**NELSON GEOTECHNICAL  
ASSOCIATES, INC.**

Geotechnical Plan Review Letter  
**Hu Residence Development**  
**30XX – 69<sup>th</sup> Avenue SE**  
**Mercer Island, Washington**  
NGA File No. 11448B20

SH4.0

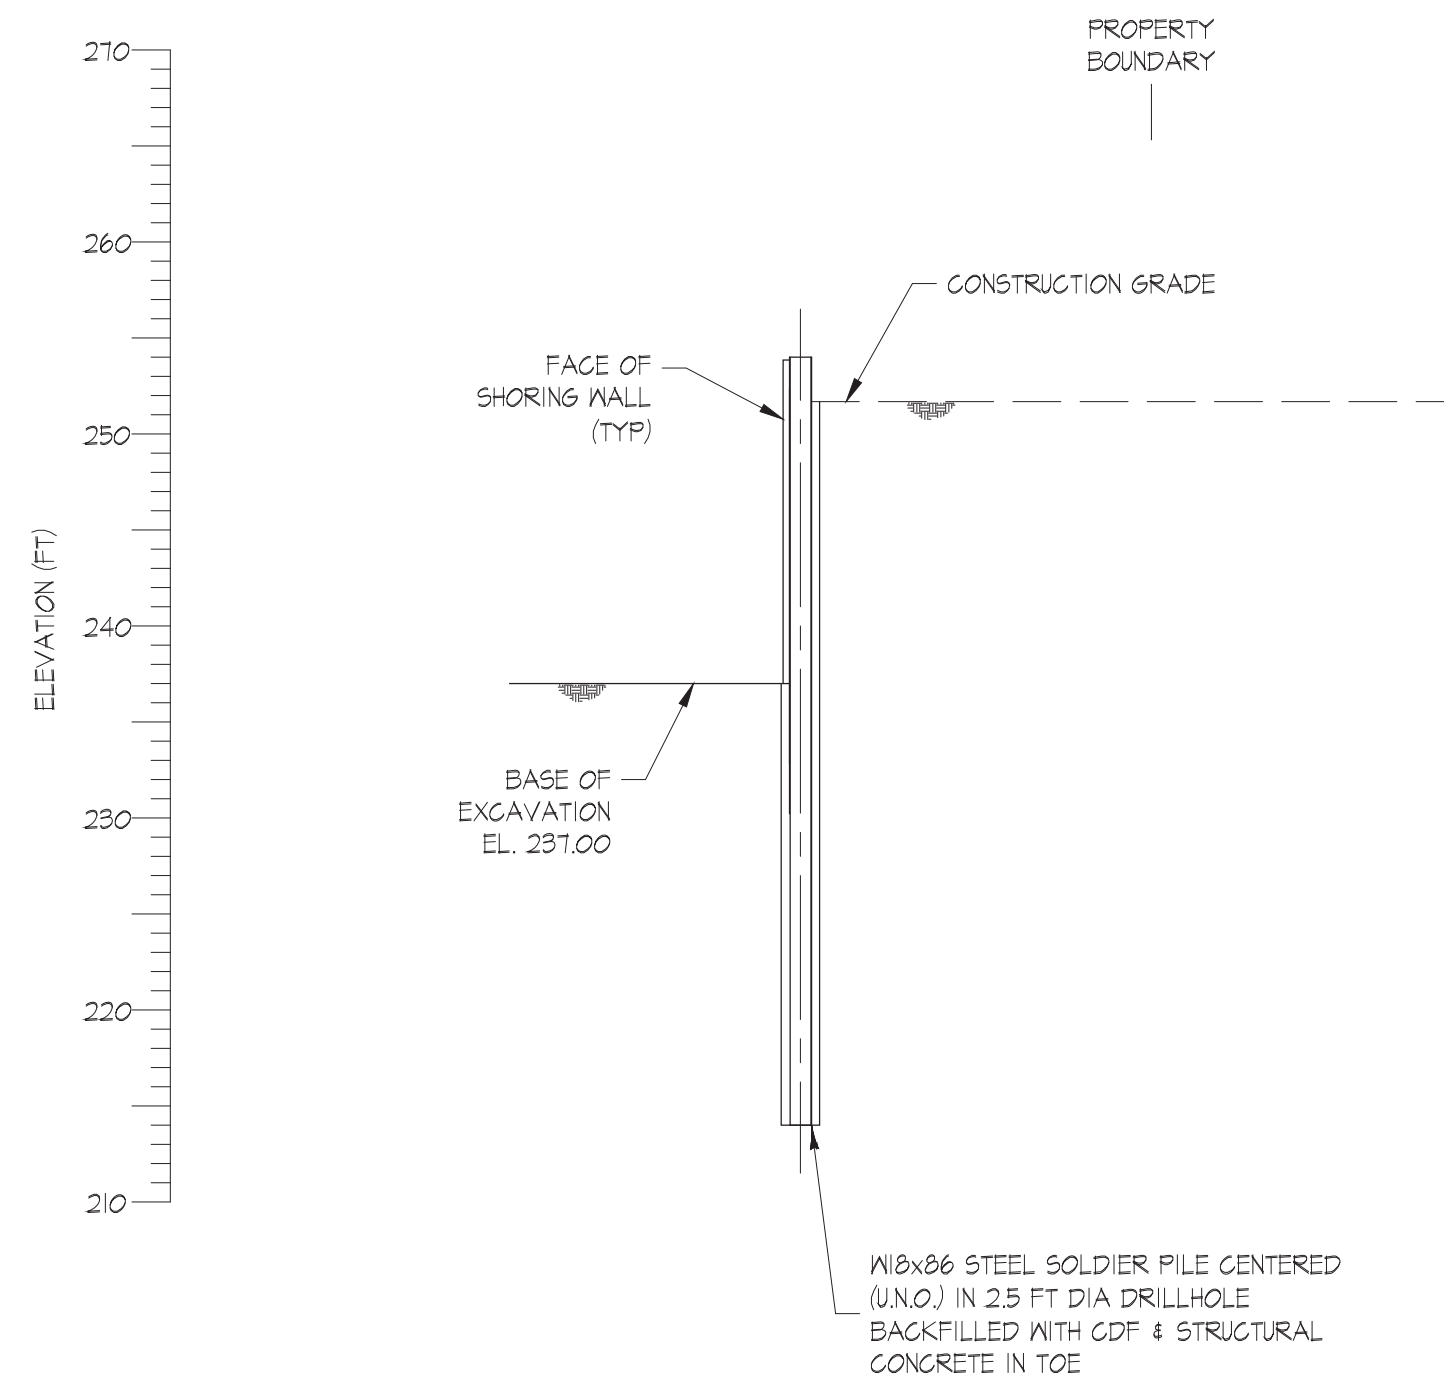
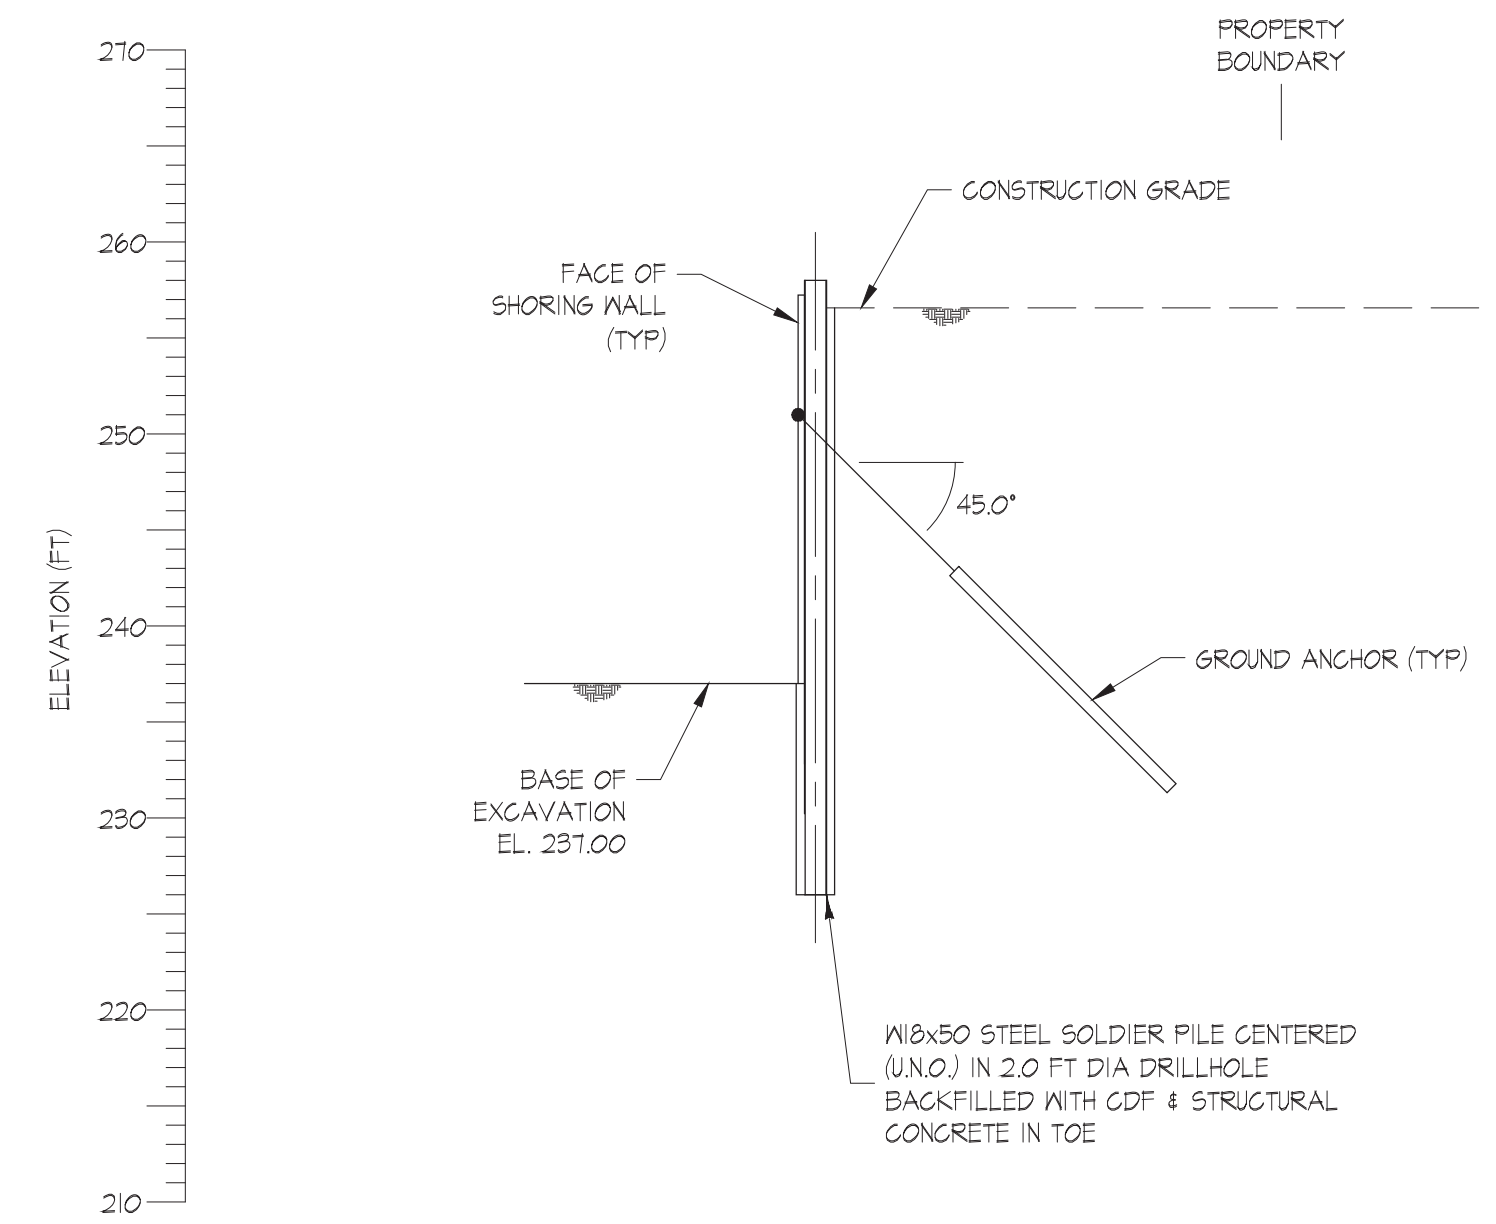
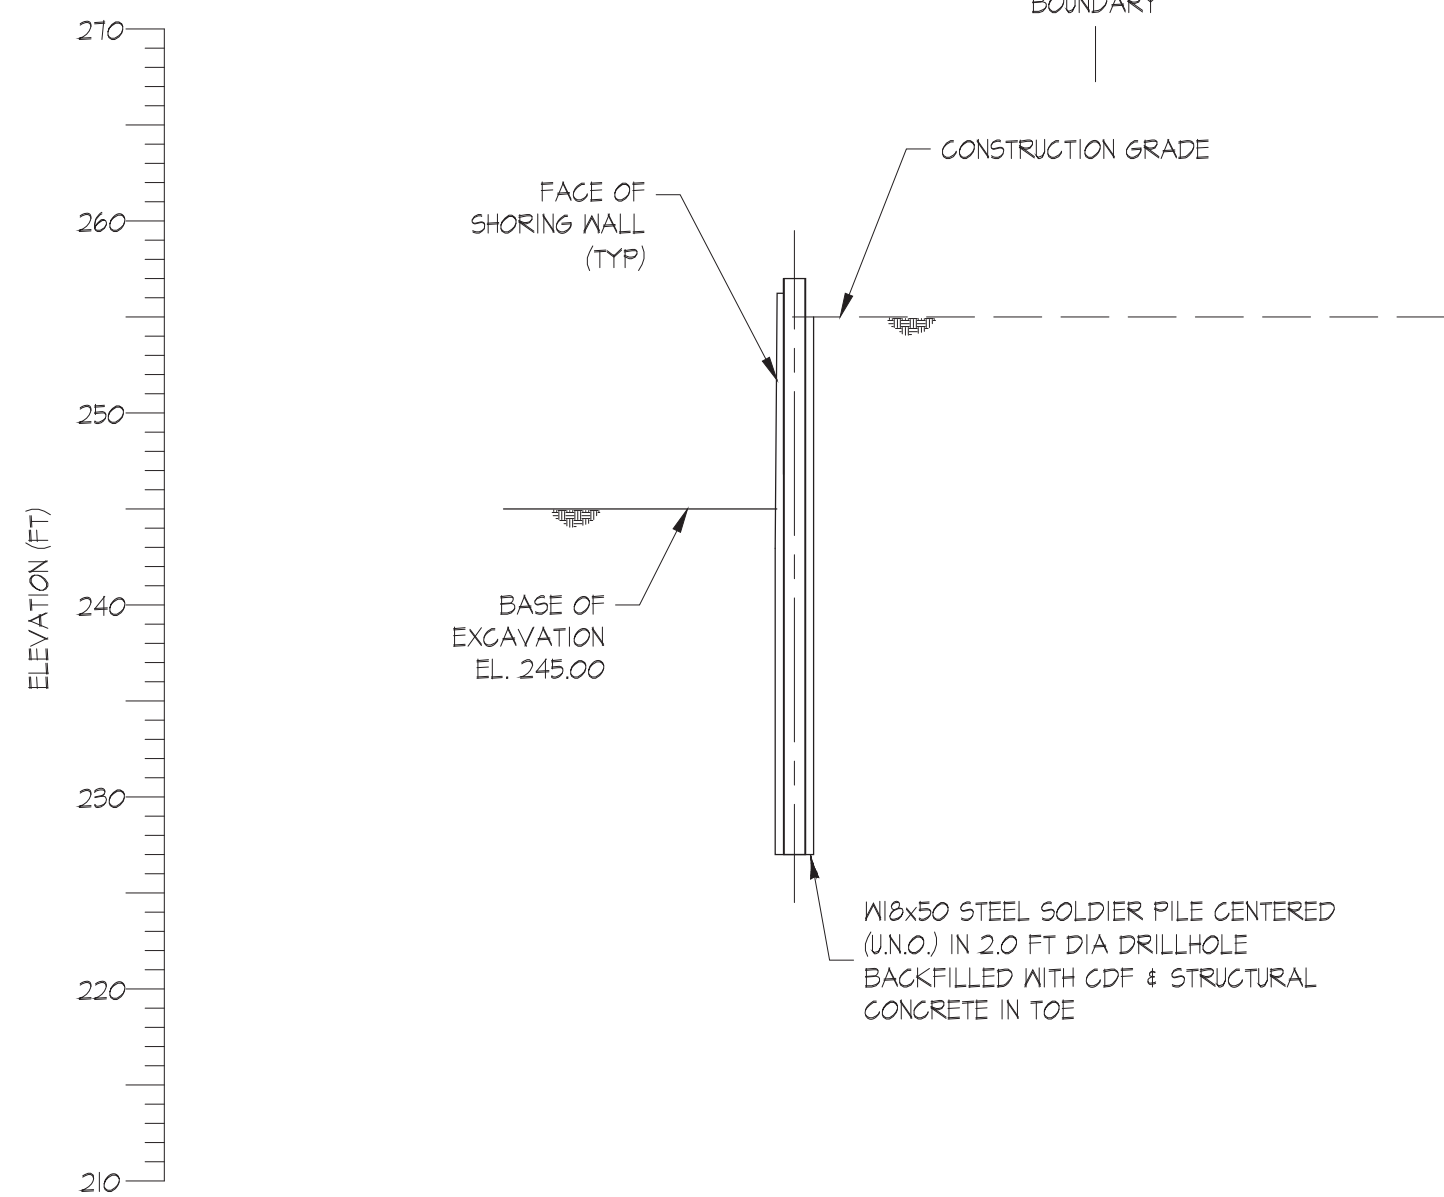
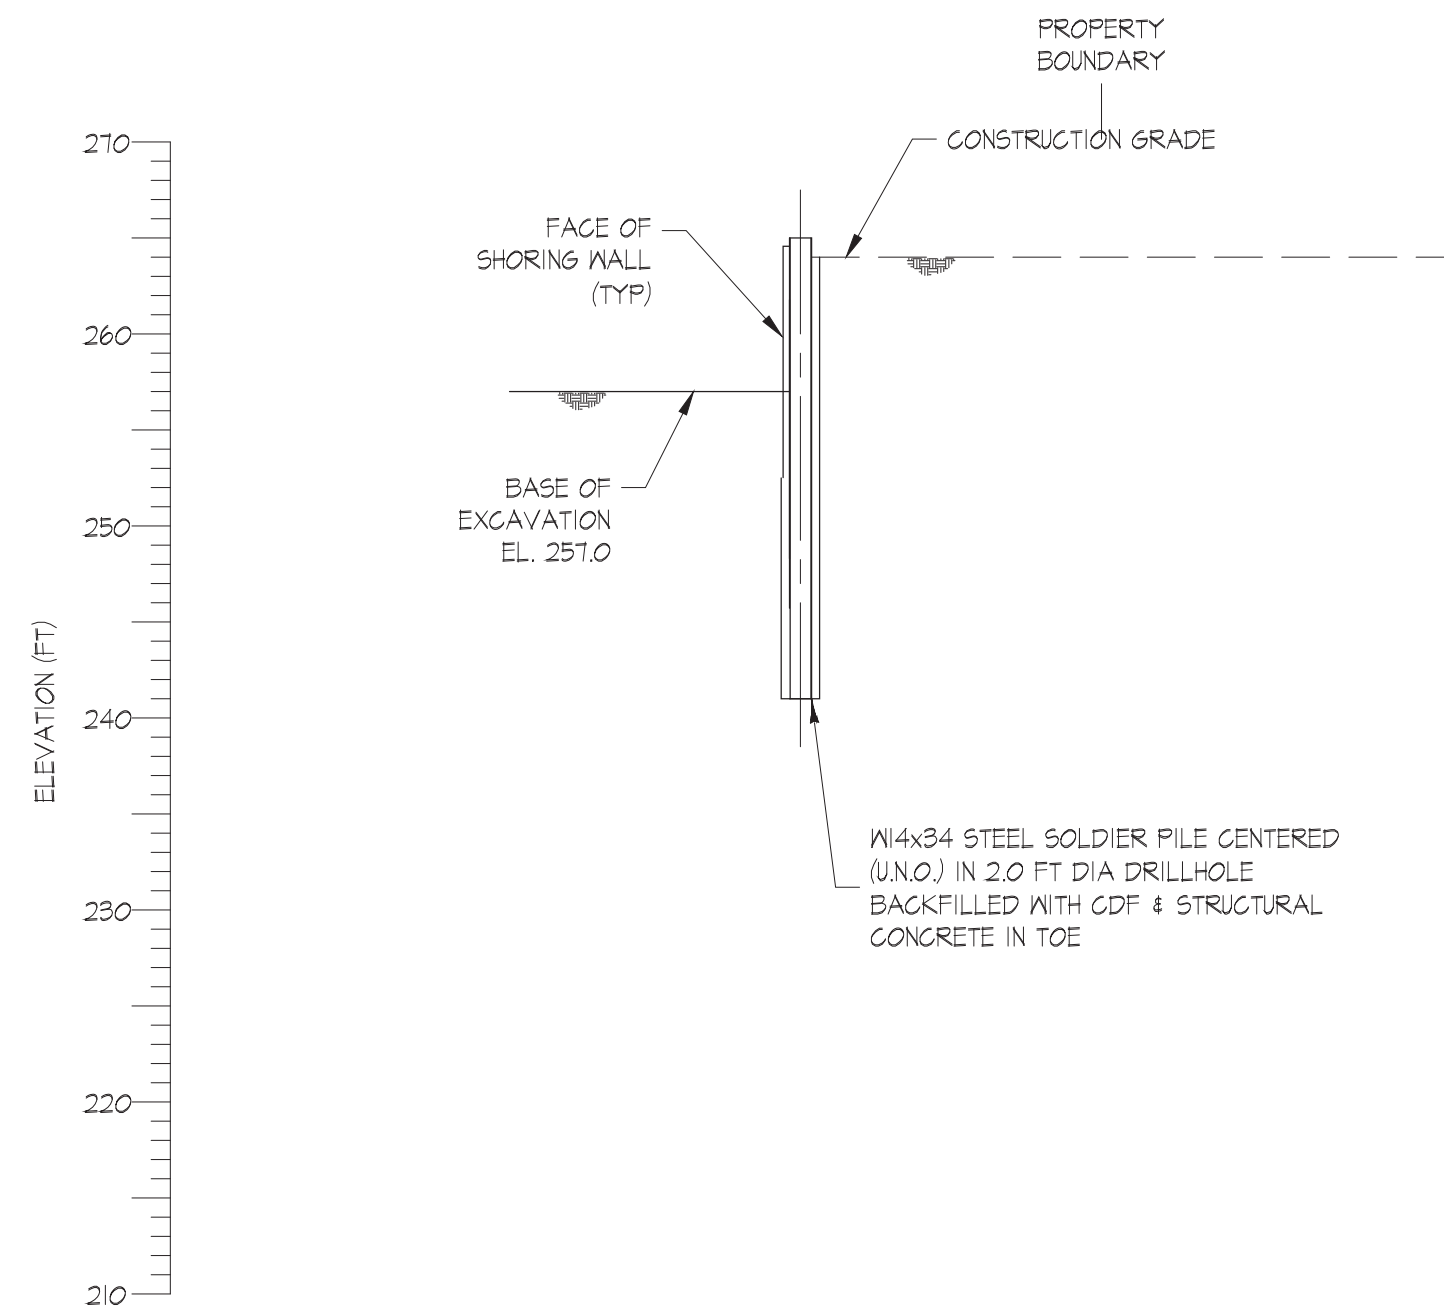
A City review comment on **Sheet SH4.0** concerns the depth to bearing soil along a retaining wall north of the residence. A previous note on the shoring plan stated “lower of base of excavation or depth to load bearing soils.” The comment questioned if the notation of “depth to load bearing soils” should be removed, and it has been removed.

A City review comment on **Sheet SH4.0** states that the geotechnical engineer of record should provide shoring design recommendations to account for surcharges, allowable end bearing, skin friction, and anchor design. We provided variable active earth pressures to account for sloping backslope conditions behind the planned shoring in the previous section of this letter. We provided geotechnical recommendations for the design and installation of shoring tieback anchors in our November 11, 2020 memo. Provided loose soil is removed from the bottom of the soldier pile holes before concrete placement, each pile will have an allowable end bearing capacity of 10 tons. We expect that end bearing capacity will be adequate to resist the downward component of the anchors, and no skin friction on the soldier piles will be needed.
